Immingham Eastern Ro-Ro Terminal

## **Deadline 6 Appendix**

**IMMINGHAM EASTERN RO-RO TERMINAL DEVELOPMENT**

**RESPONSE TO CONSULTATION ON PROPOSED CHANGES TO THE APPLICATION**

Drawing number
B2429400-JAC-00-ZZ-DR-ZZ-0201

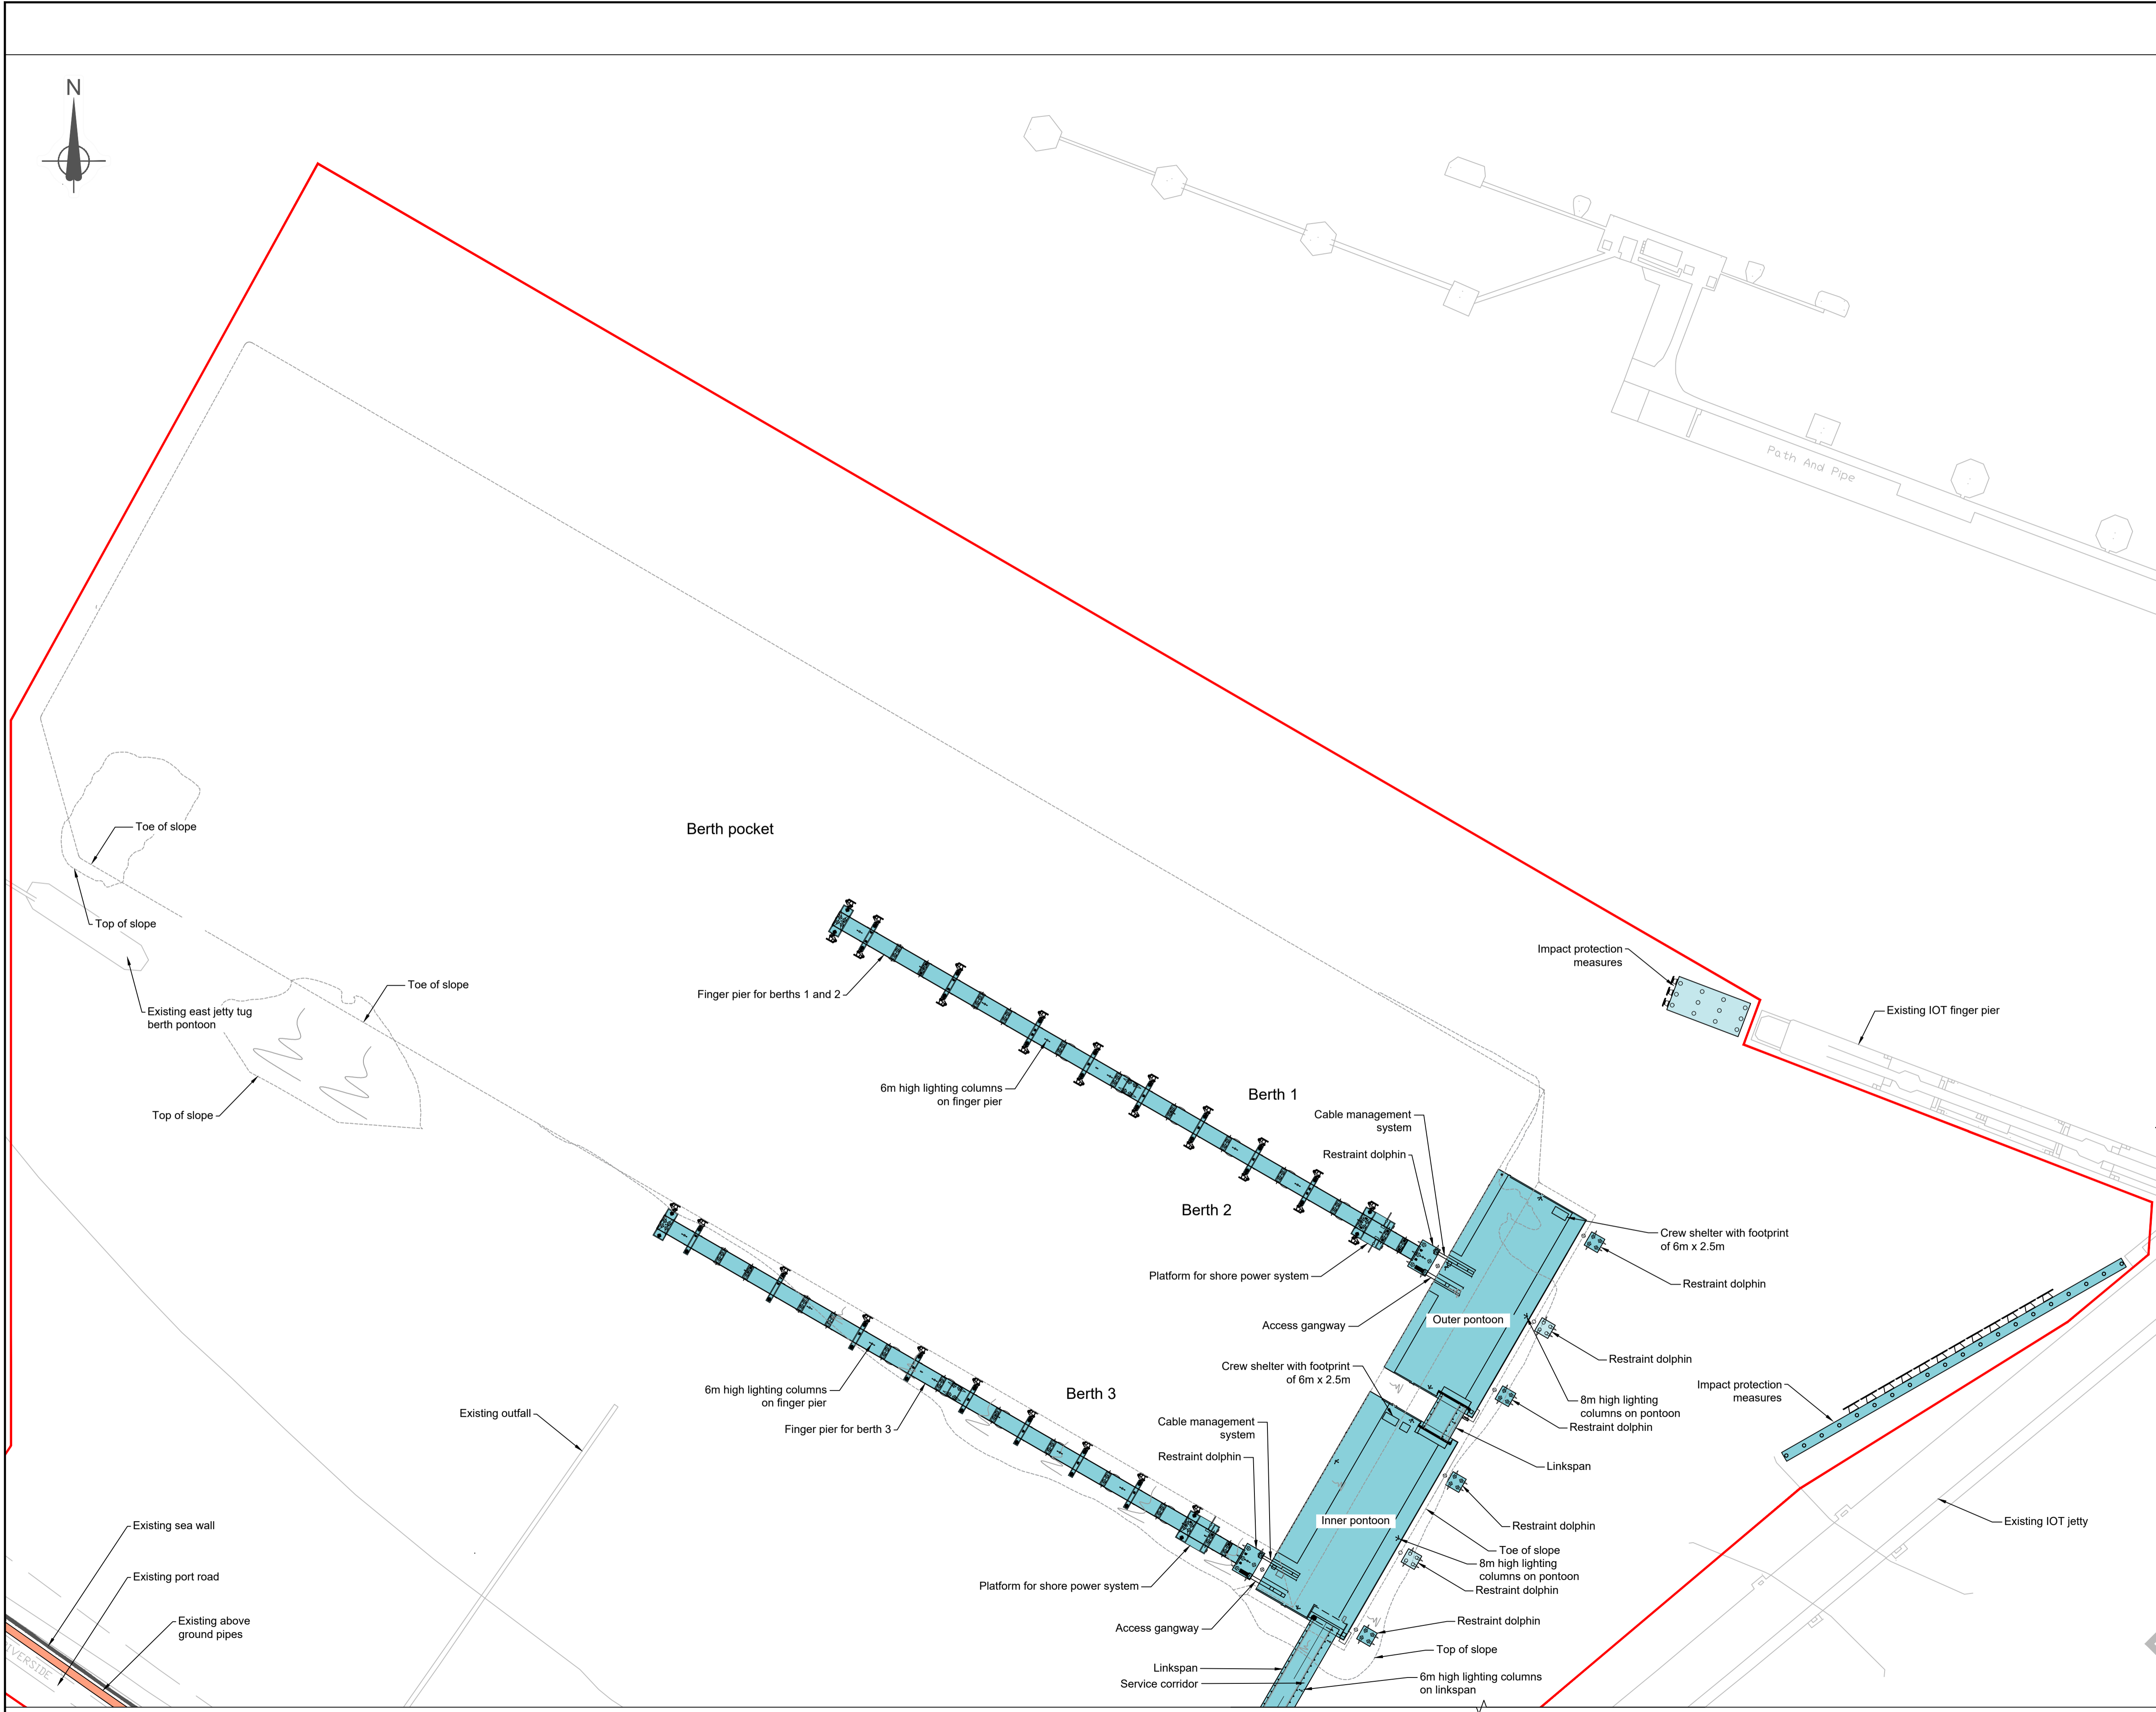
- 2.1 At para. 2.13 of the change request **Restraint dolphins** are included, which the Applicant ABP notes include up to two additional restraint dolphins for each of the landing pontoons to improve stability. These are identified in "*Figure 2 – Proposed realignment of the Approach Jetty and related works*" – see figure above with restraint dolphins identified by orange pecked line. At Section 3.1 of the Change Request, which describes the "Rationale and Need for the Changes", restraint dolphins are conspicuous by their absence and as such no details are provided by the Applicant justifying the need for restraint dolphins.

- 2.4 However, the IOT Operators' are not able to understand:
- (a) The calculations which have informed the design details which are being used in the Applicant's change request; or

(b) Where any updated NRA has been carried out to understand the effectiveness of the proposed restraint dolphins to mitigate allision risk.

- 2.6 Without the justification behind the design basis for the change to include additional restraint dolphins to the pontoons, the IOT Operators assume that the inclusion of the restraint dolphins, if constructed, would be to provide additional “implicit” impact protection to the IERRT structure, and as such provide additional protection to the IOT Trunkway. Therefore, IOT Operators require both the engineering design and impact loading parameters to be provided showing what the effect the restraint dolphins have on mitigating allision of an IERRT vessel with the IOT Trunkway, and separately mitigate the risk of the pontoons from becoming detached such that they may collide with the IOT Trunkway. It is also noted that para. 2.210 of Appendix 1 notes that the pile size of the restraint dolphins is proposed to be increased from 1,422mm to 1,520mm.

- 2.9 At para. 2.14 the Applicant notes that two additional piles to support mooring bollards have been added to improve mooring performance. The IOT Operators note that, as with the restraint dolphins, no details are provided by the Applicant to justify the inclusion of these additional piles. To date, no details other

2.36 It is also noted that Para. 2.5.2 of Appendix 1 indicates that the pile sizes of the linear impact protection measures is proposed to be increased from 1,422mm to 1,520mm. However, there is no detail or basis
